Recommendation Report for Planning Permission

REF NO: LU/174/21/PL

LOCATION: 44-48 High Street
Littlehampton
BN17 5ED

PROPOSAL: Replacement of 14 No. timber frame sash windows and 1 No. timber frame bay window to residential units. This application is in CIL Zone 4 (zero rated) as other development.

| Project<br>Proposed | Sheet<br>1/1 |

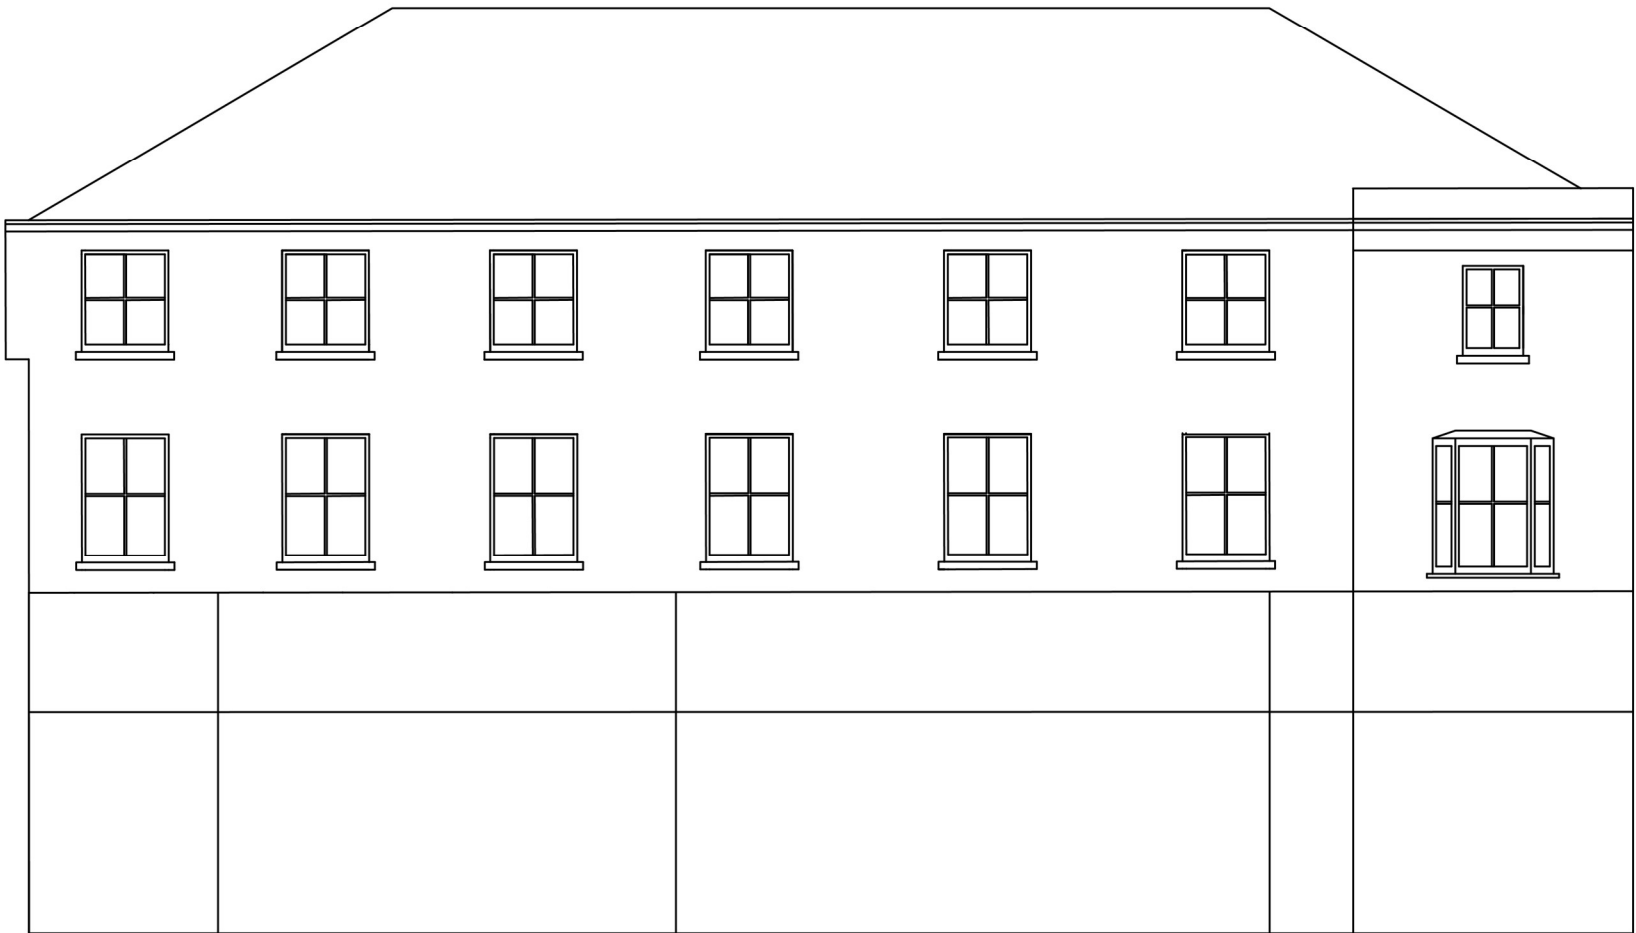
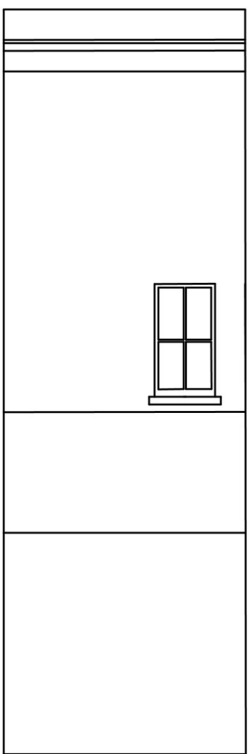
ADC Conservation Officer - The windows would be harmful to the historic building. If the appearance of the windows is to remain the same, and the dimensions of the frames and glazing bars similar to the existing ones, the impact could be reduced.

Under para 203 of the NPPF it is considered on balance that the scheme would not cause any harm or loss to the non designated heritage asset due to its sympathetic design and the fact that the dimensions of the frames and glazing bars are the same size as existing. The use of UPVC in this case is considered acceptable because it is a building of character and the replacement windows are like for like. The windows are considered to be sympathetic with the building as a whole and would preserve the historic interest in the building in accordance with policy HER DM3 of the Arun Local Plan and policy 17 of Littlehampton Neighbourhood Plan.
